Application No: CM/17/21/PL
Site Address: Land at Wren Cottage Horsemere Green Lane Climping BN17 5QZ
Description of works: Development of 2 No. 2-bed & 2 No. 3-bed detached dwellings & associated works (resubmission following CM/53/20/PL). This site is in CIL Zone 3 & is CIL Liable as new dwellings.

Thank you for your internet representation made on 17th July 2021 which has been recorded as an objection with the comments as follows:

PLOT 1 FLOOR PLANS
SCALE 1:100 @ a3

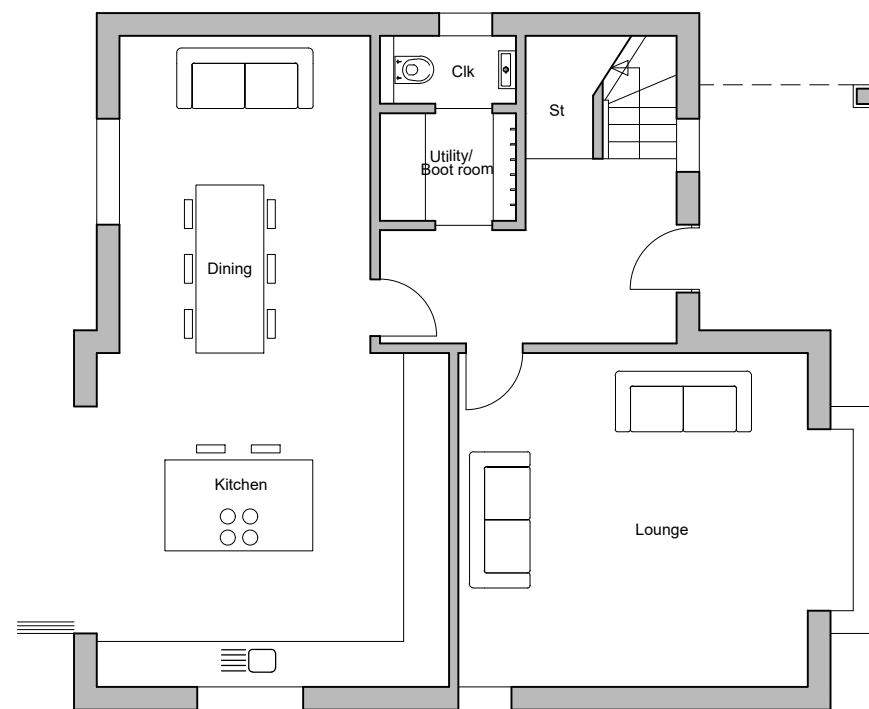
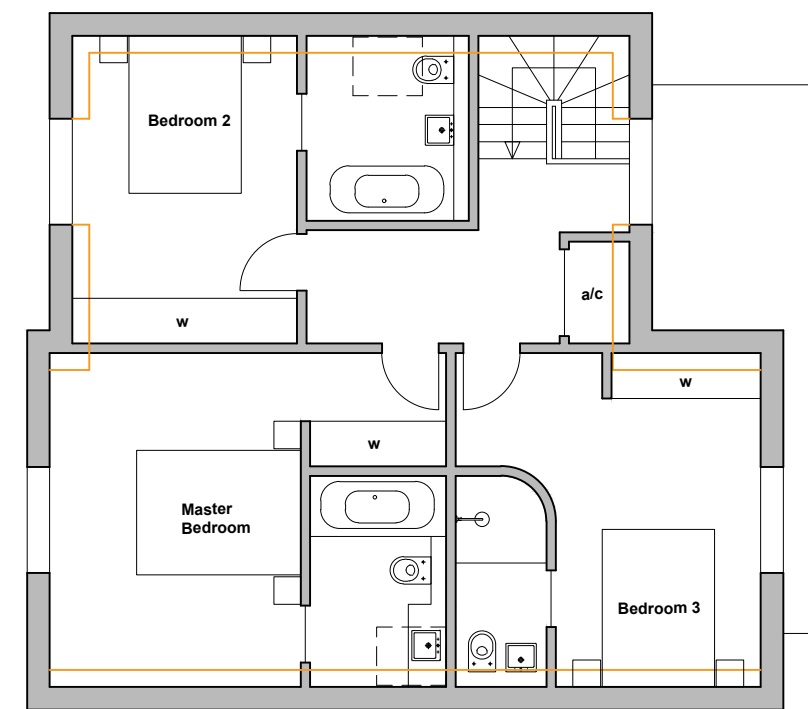
Can you explain why it still remains a large 3 bedroom house with 2 bedrooms facing west each with double windows overlooking 4 Wooldridge Walk's garden and into its 2 back bedrooms.

PLOT 1 ELEVATIONS
SCALE 1:100 @ a3

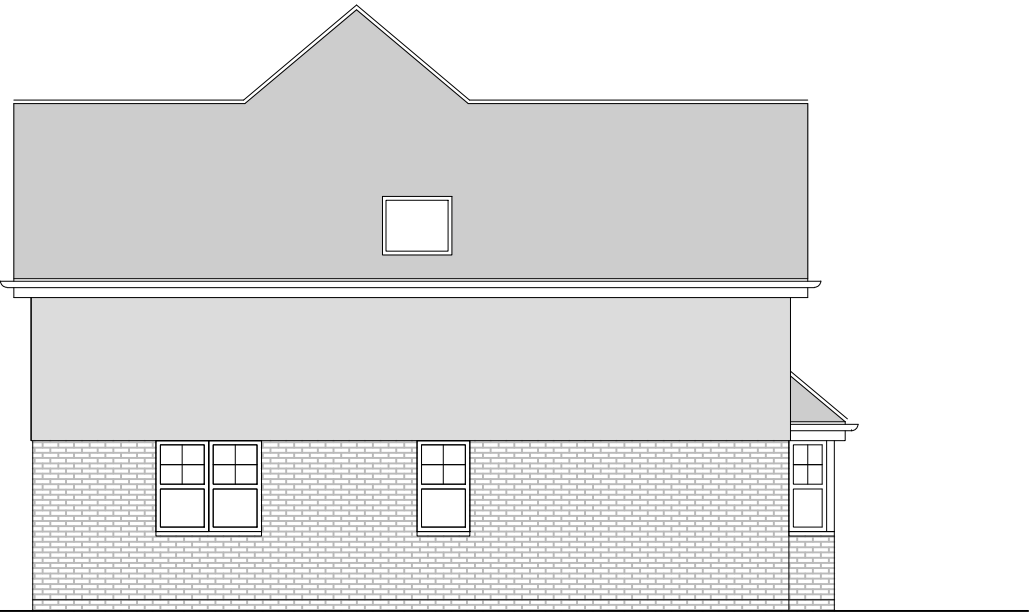
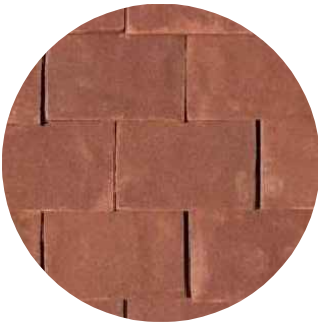
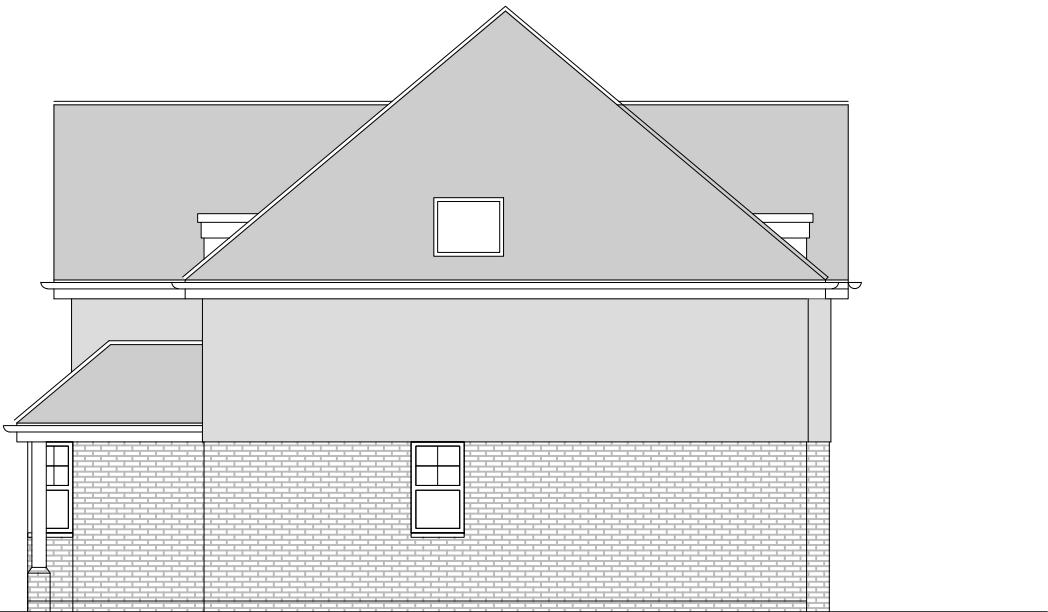
We are perplexed as to why plots 2 to 4 have had significant changes from the original plans all in favour of the residents of numbers 5 to 7 Wooldridge Walk but Plot 1 which overlooks and invades the privacy of 4 Wooldridge Walk has been left out in the cold and has had no changes to the original plans whatsoever.
